**Recommendation Report for Listed Building Consent for Alterations, Extension or Demolition of a
Listed Building**

REF NO: AB/99/18/L

LOCATION: 44 Tarrant Street
Arundel
BN18 9DN

PROPOSAL: Listed Building Consent to renovate & refurbish bathrooms, repair cellar & move kitchen to lower ground floor, renovate fireplaces & staircases, renovate window mechanisms, strengthen undulating floors & replace existing roof light.

PROPOSED BASEMENT FLOOR PLAN

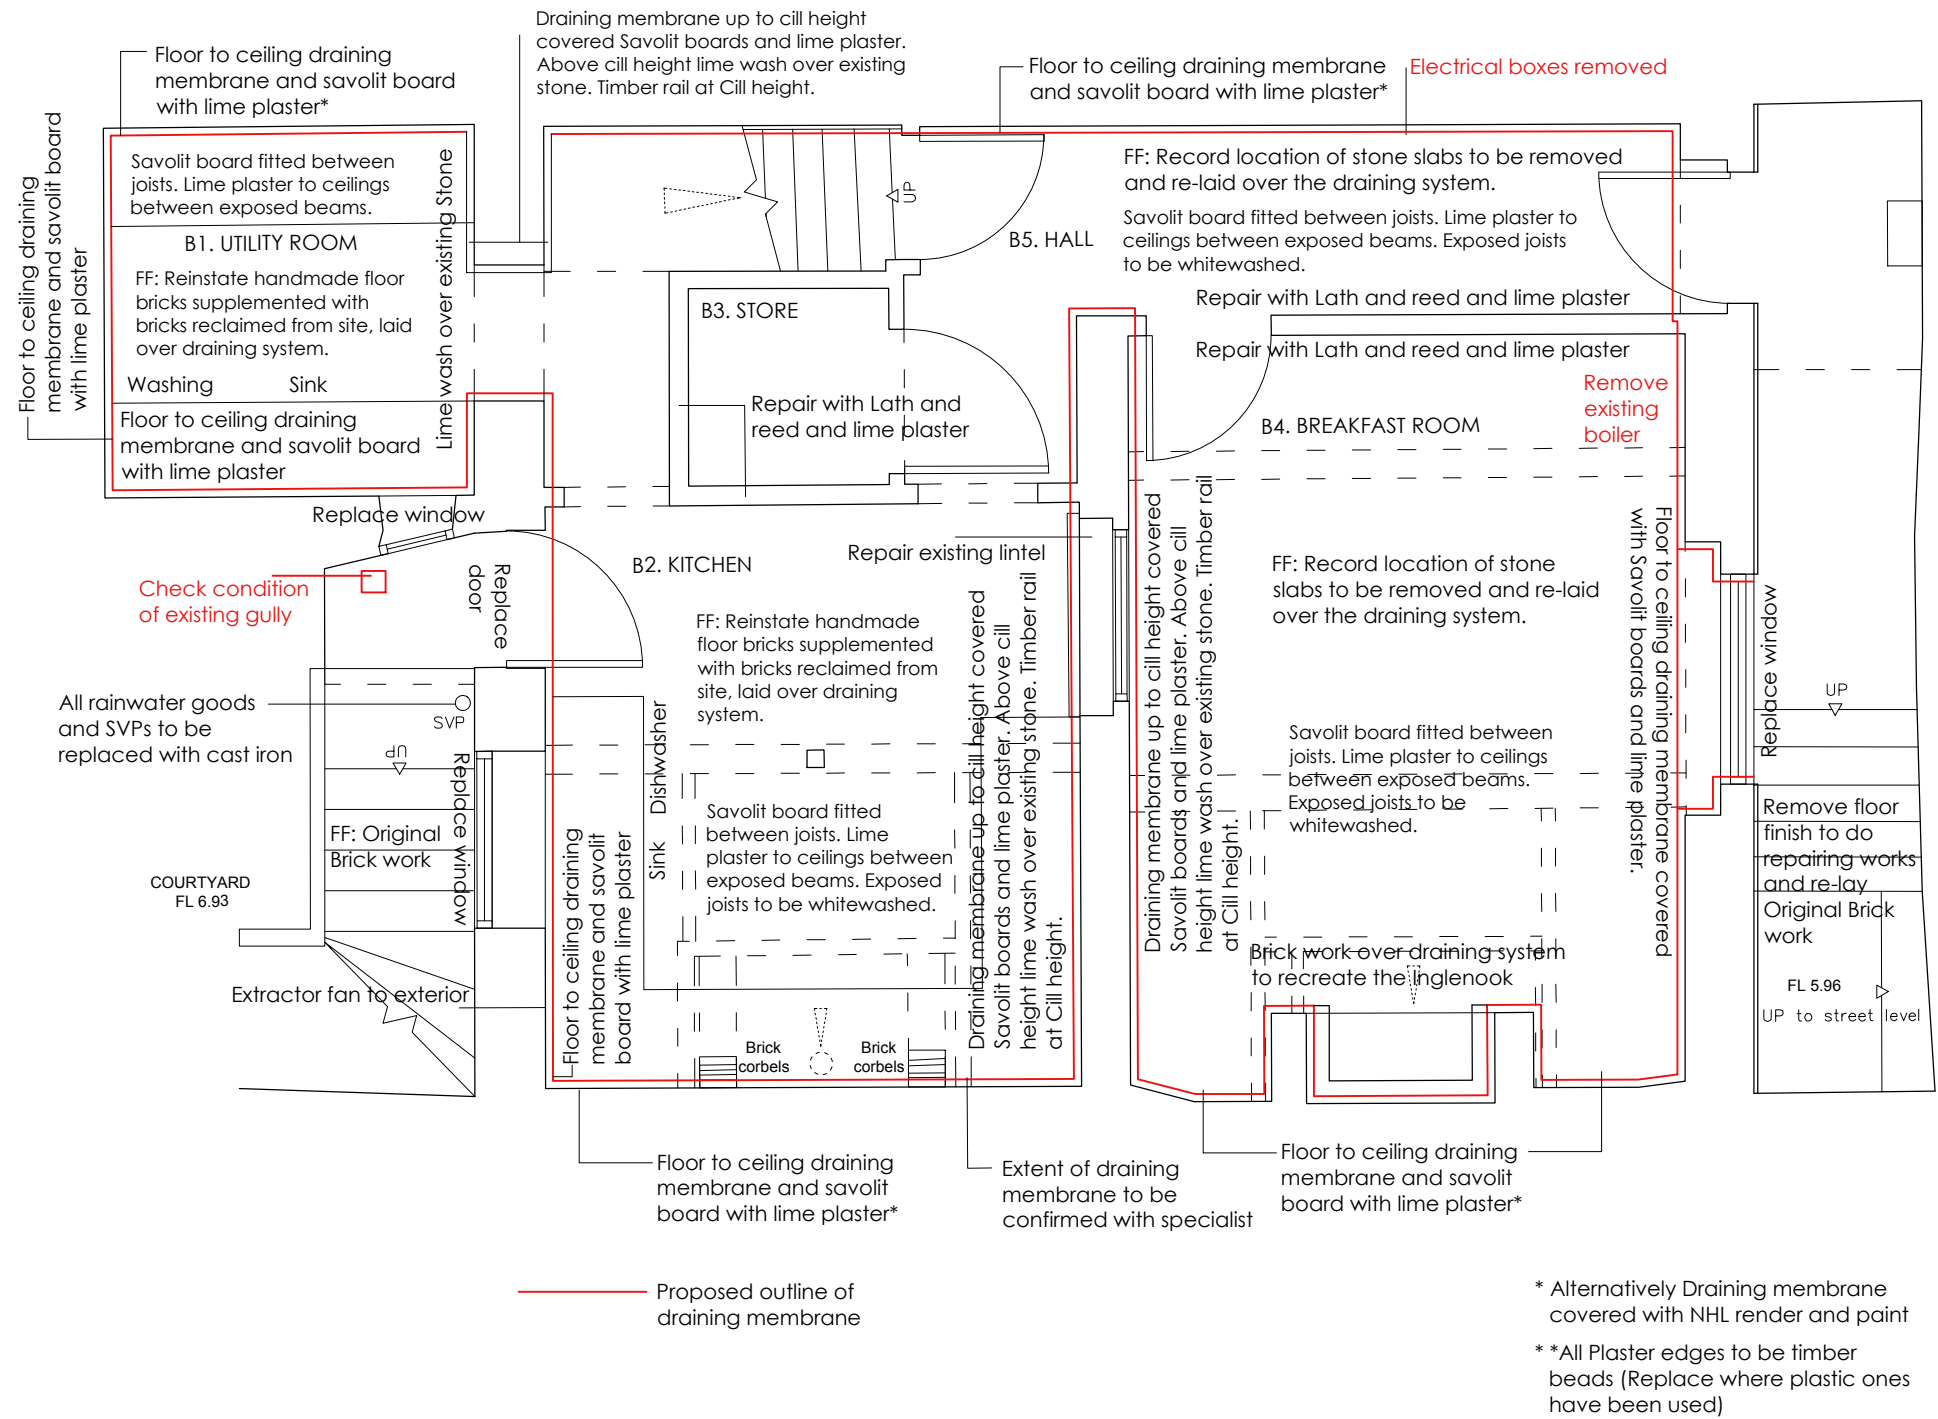
The proposal for the meters in the hallway to be reconfigured in order to take less space, will allow for the hall way to be de-cluttered. This is a positive impact.

The proposed tanking system seems to be acceptable in this instance, as long as it allows the building to 'breathe', whilst remaining dry. I note from the application that the intention is to hide the system behind boarding to window cill height, so as to minimise the impact upon the room. Such an approach is positive. It is assumed that the applicant has limited the amount of tanking required.

The flooring within the basement is of particular interest, and plays a role in the significance of the space. Any works to it should be undertaken with great care. The installation of the tanking system referred to by the applicant will have a direct impact upon the floor, and the applicant will need to submit a methodology which clearly indicates how its significance and character will not be affected in a negative way.

The flooring will need to be re-laid exactly as it currently is, so that its character is not harmed. The statement will need to include information on how the flooring looks like now (including pictures and relevant drawings), removed, stored and re-laid.

- 7 Prior to any works to the basement flooring commencing a methodology for its re-laying, to include a recording of the floor prior to the works, how it is to be removed, stored and re-laid shall be submitted to and approved by the Local Planning Authority before work to the basement floor is commenced and the works shall proceed in accordance with the details so

SKIRTING BOARDS AND ARCHITRAVES SCALE 1:2

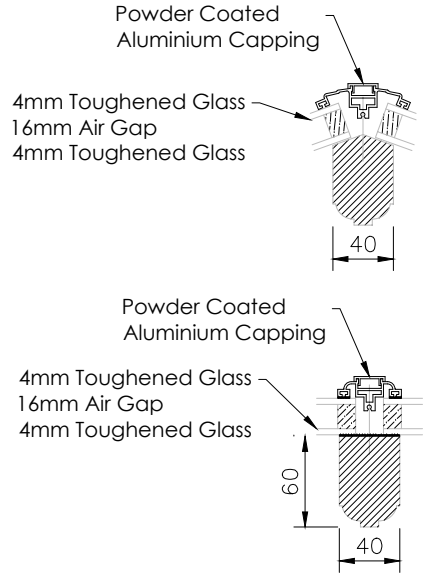
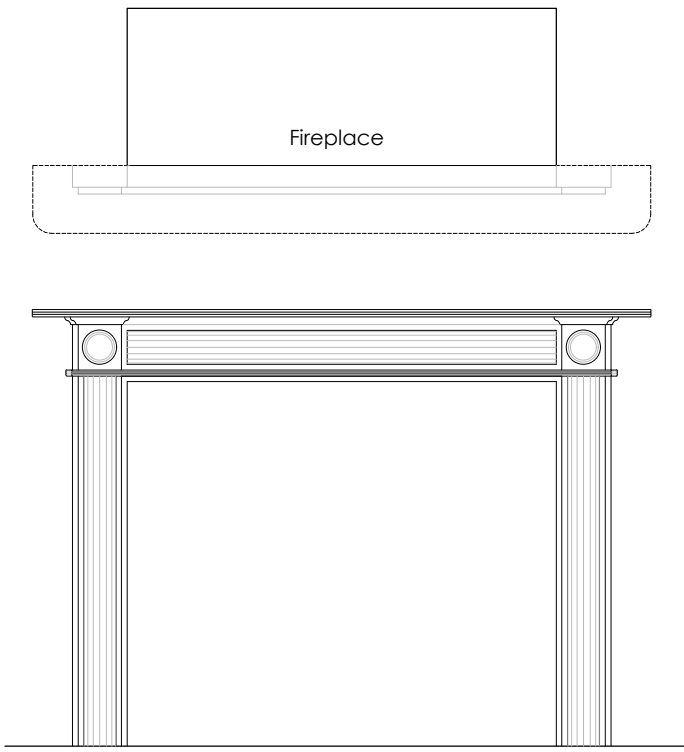
As part of the previously undertaken works, a significant amount of skirting and architrave was removed and stored within the building. It is good to see that it will be re-used within the house. Every attempt must be made to ensure that this is used in their original locations wherever possible. Where new is required it should copy the existing, traditional design and appearance. This should be dealt with by way

FIREPLACE SURROUND SCALE 1:20

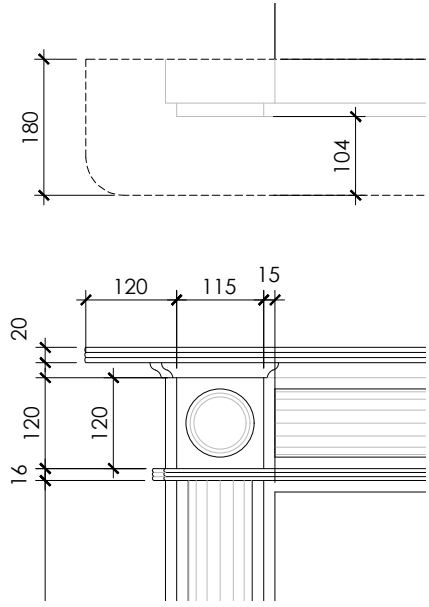
Details of fire surrounds are not provided as part of the Listed Building Consent, and will need to be provided for by way of condition. Such information is required in order to ensure that they respect the significance of the building.

- 4 Prior to installation of any fire surrounds details of the surrounds shall be submitted to and approved by the Local Planning Authority and the replacement surrounds shall accord with the approved details.
